LIBERTY TREE ACADEMY
CONSTRUCTION DOCUMENTS
TOWN OF PEYTON, EL PASO COUNTY
PRELIMINARY DESIGN
MAY 2018

LIBERTY TREE ACADEMY

TOWN OF PEYTON, EL PASO COUNTY
CONSTRUCTION DOCUMENTS

SPILLWAY SECTION (C)
SCALE: 1" = 5'

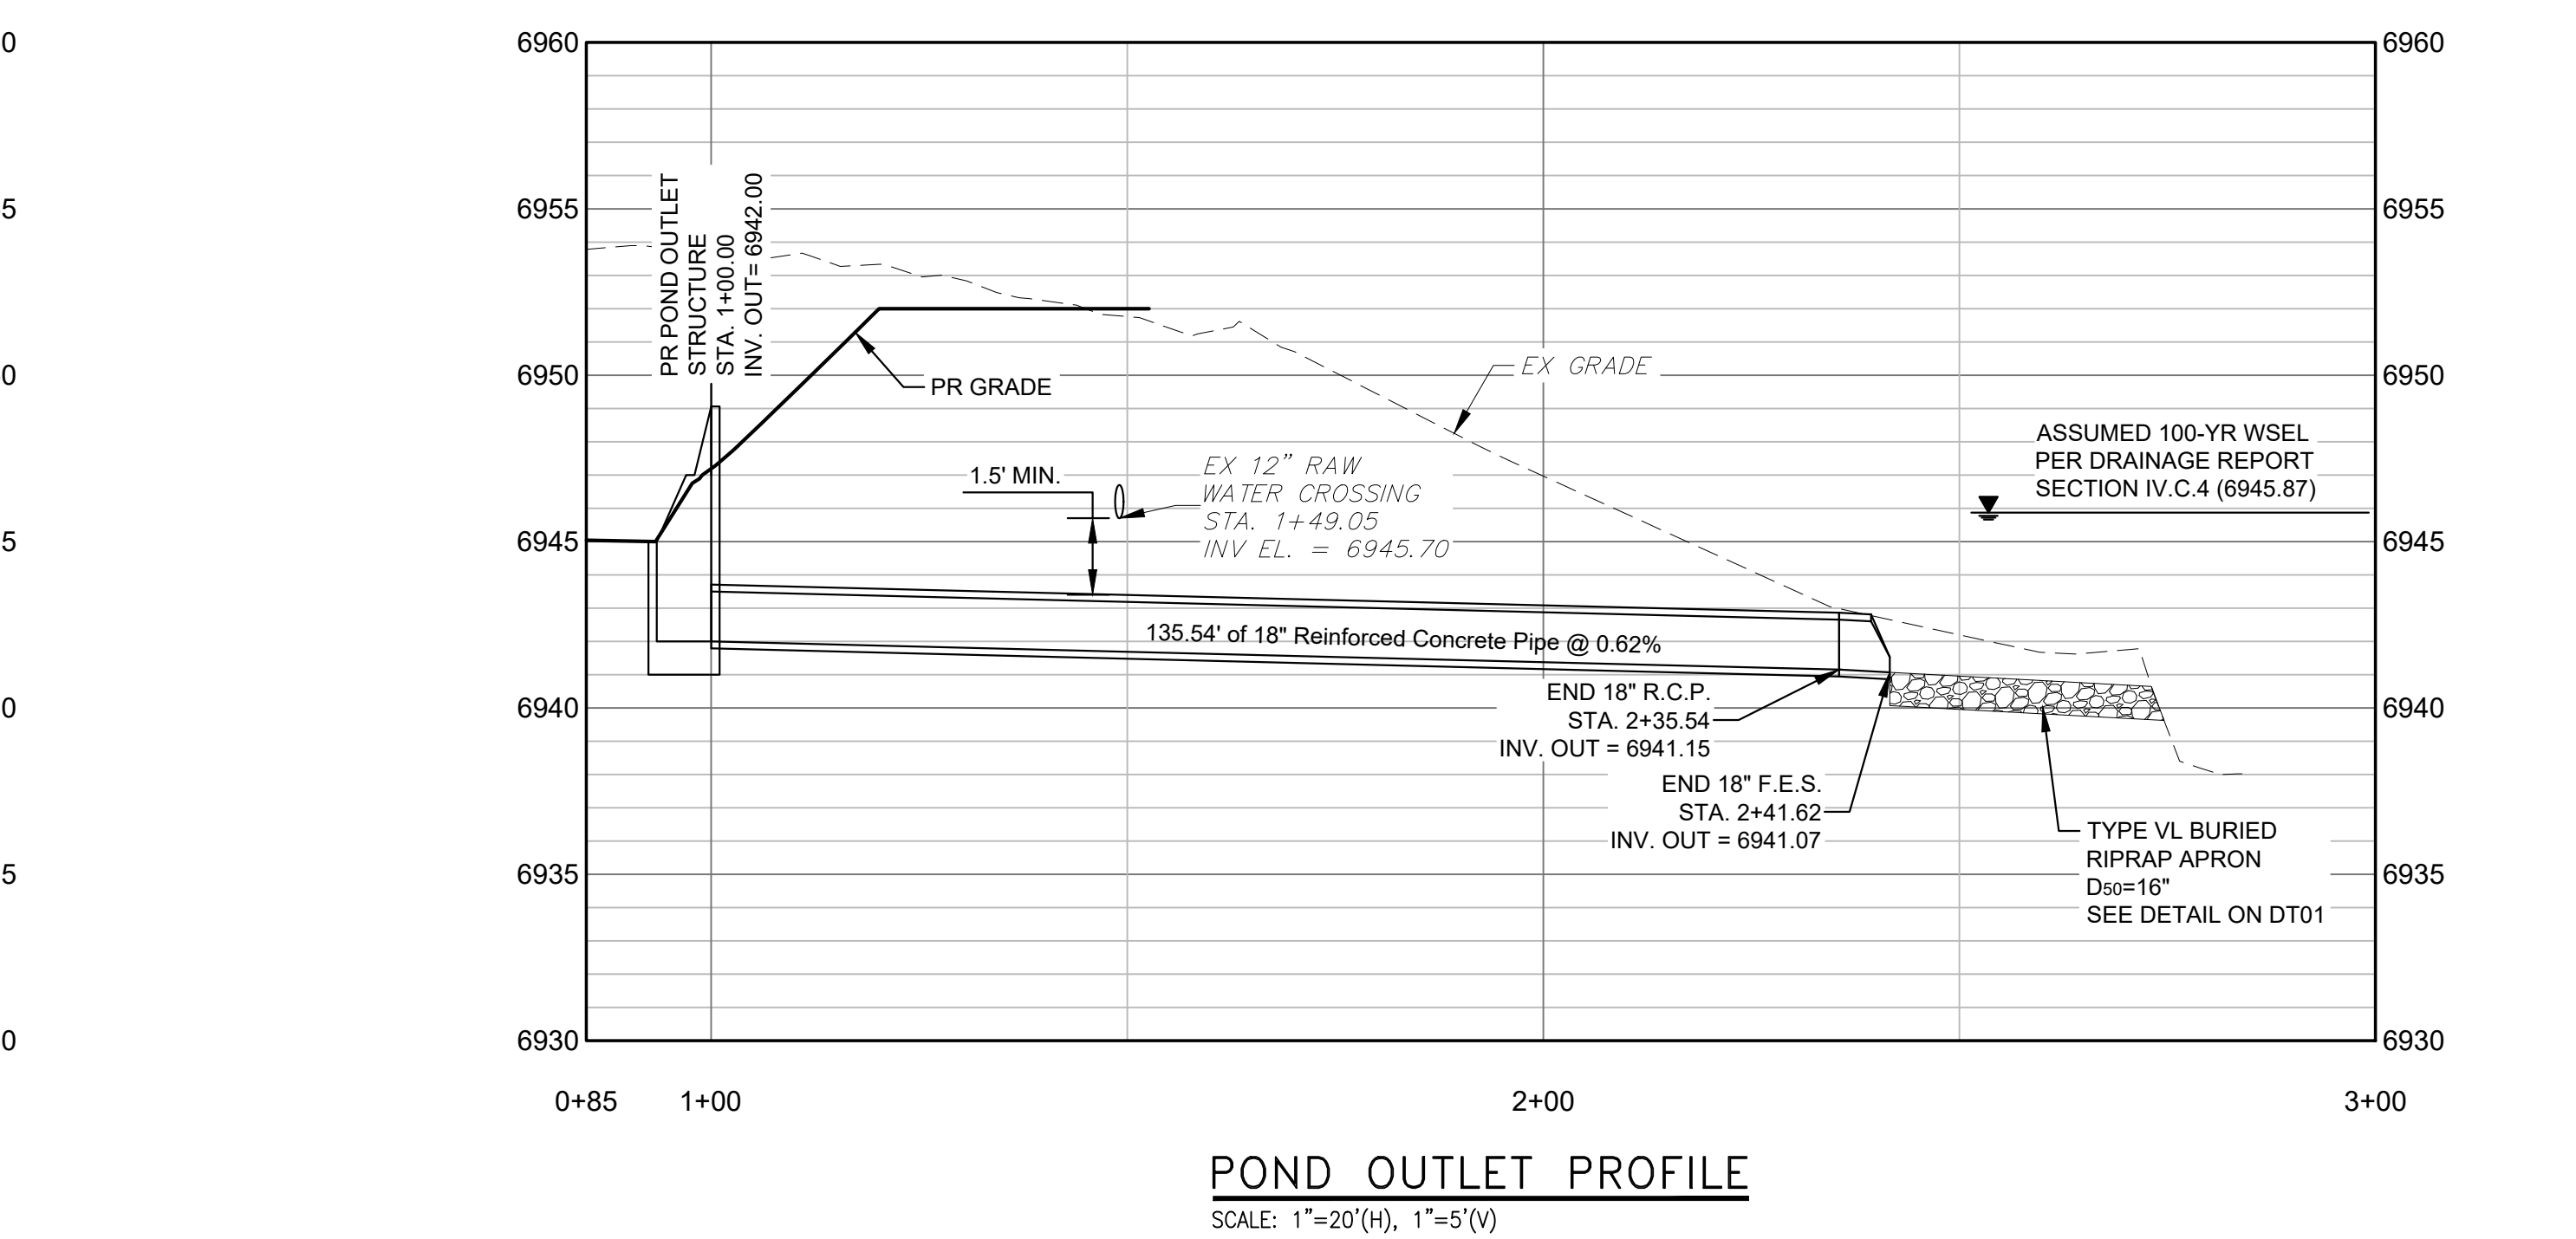
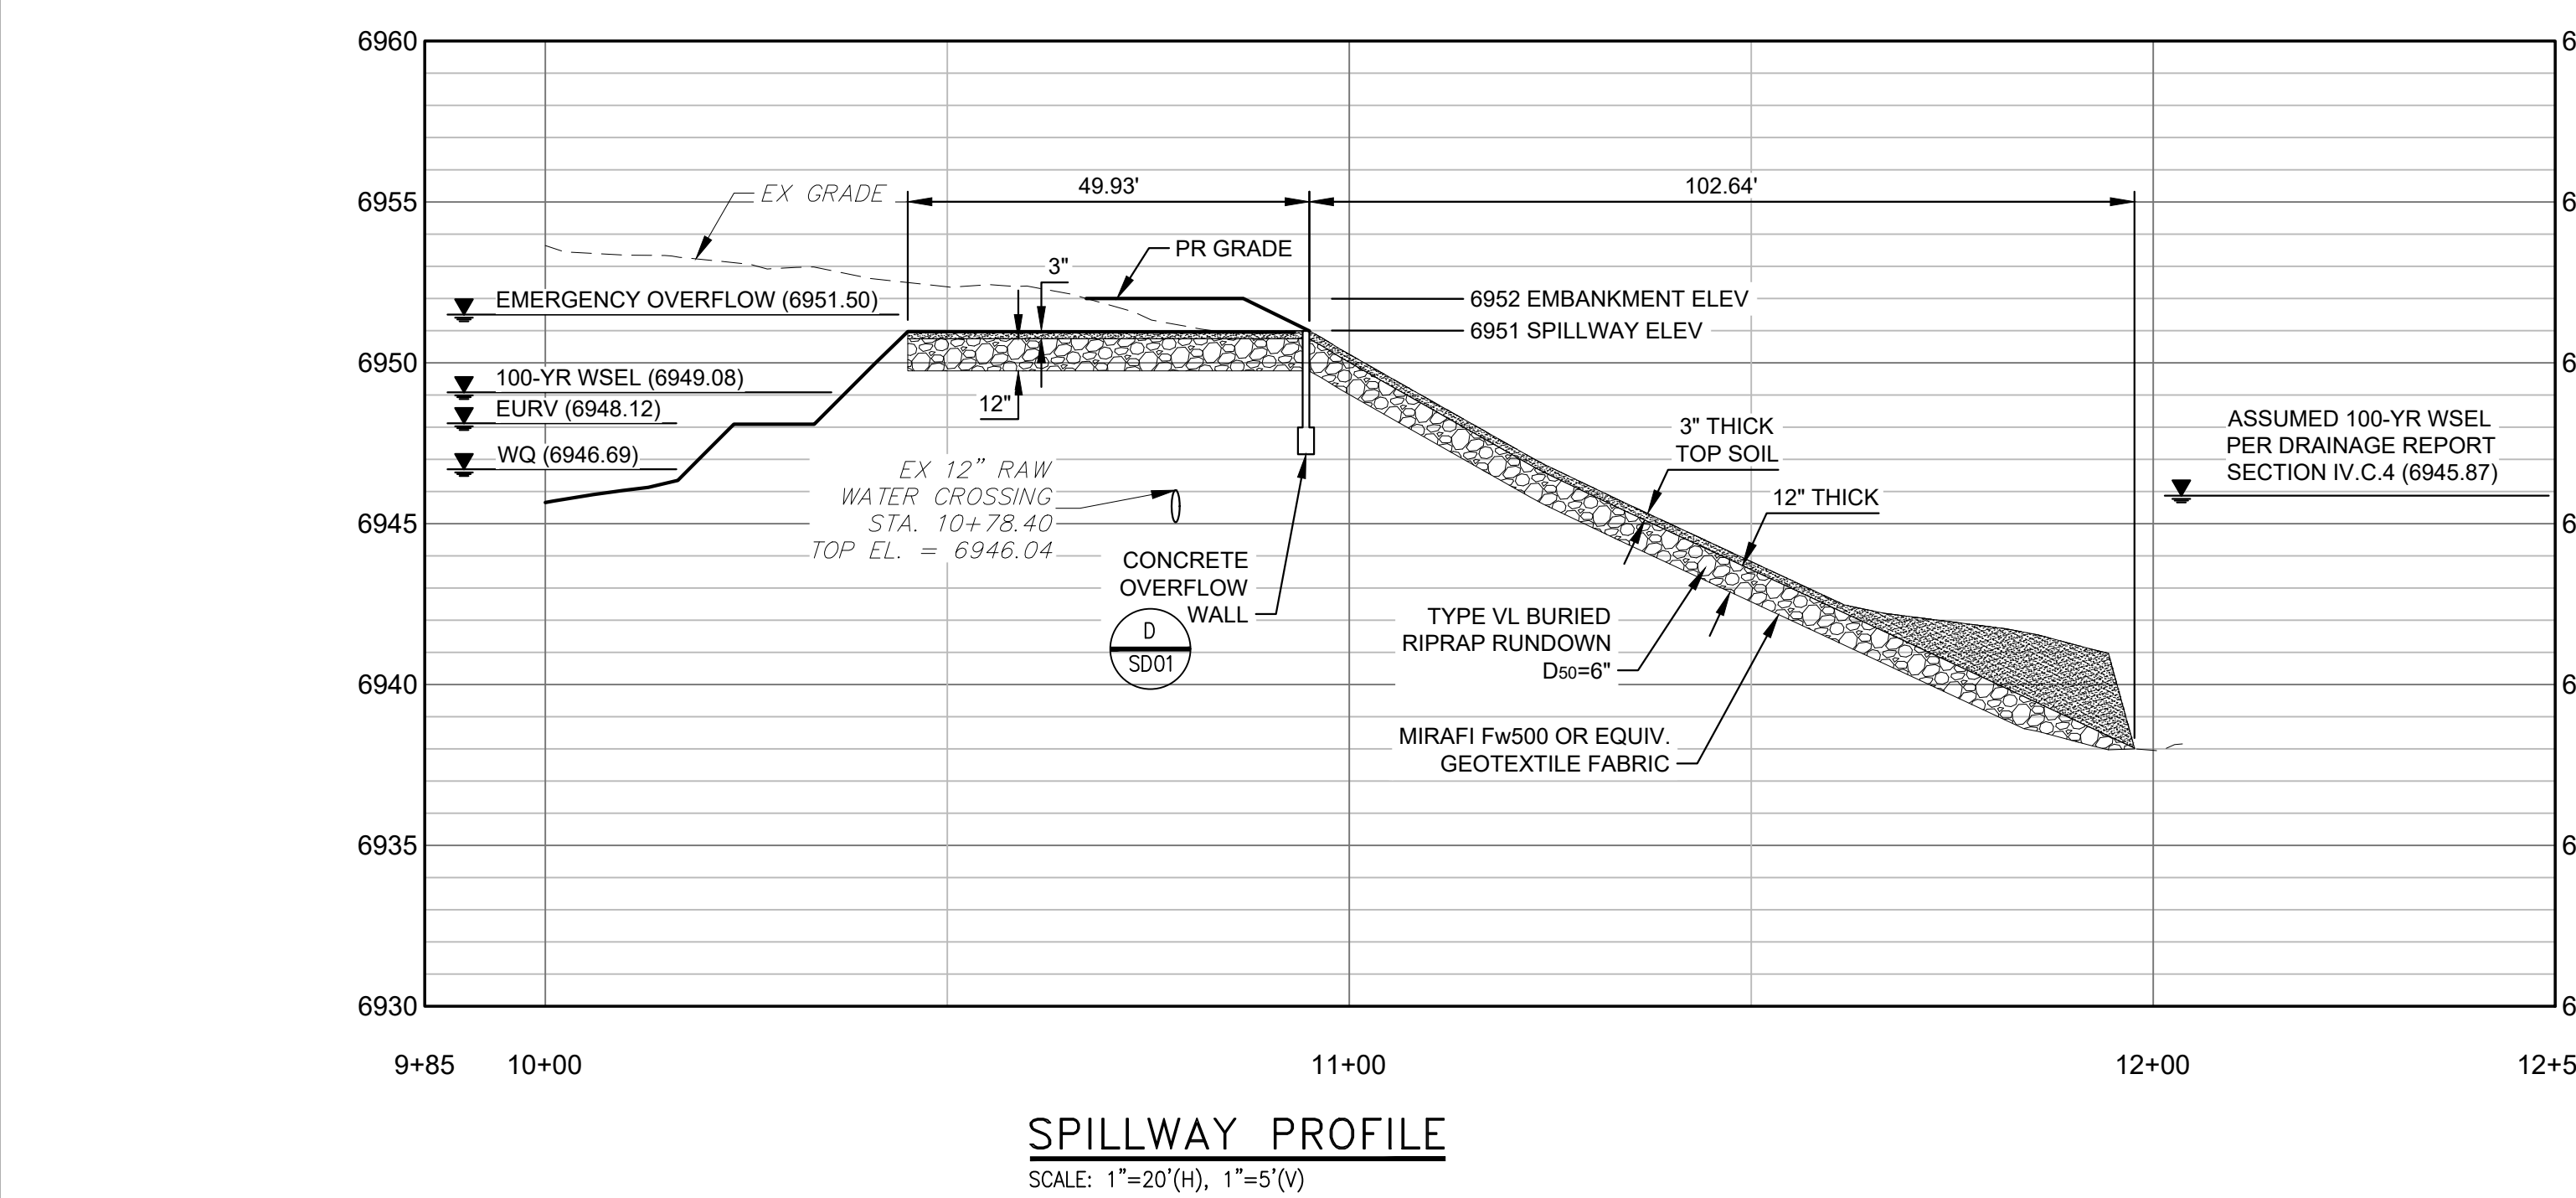
If this is a spillway
show type of erosion
protection.
**RESPONSE:
ADDRESSED**
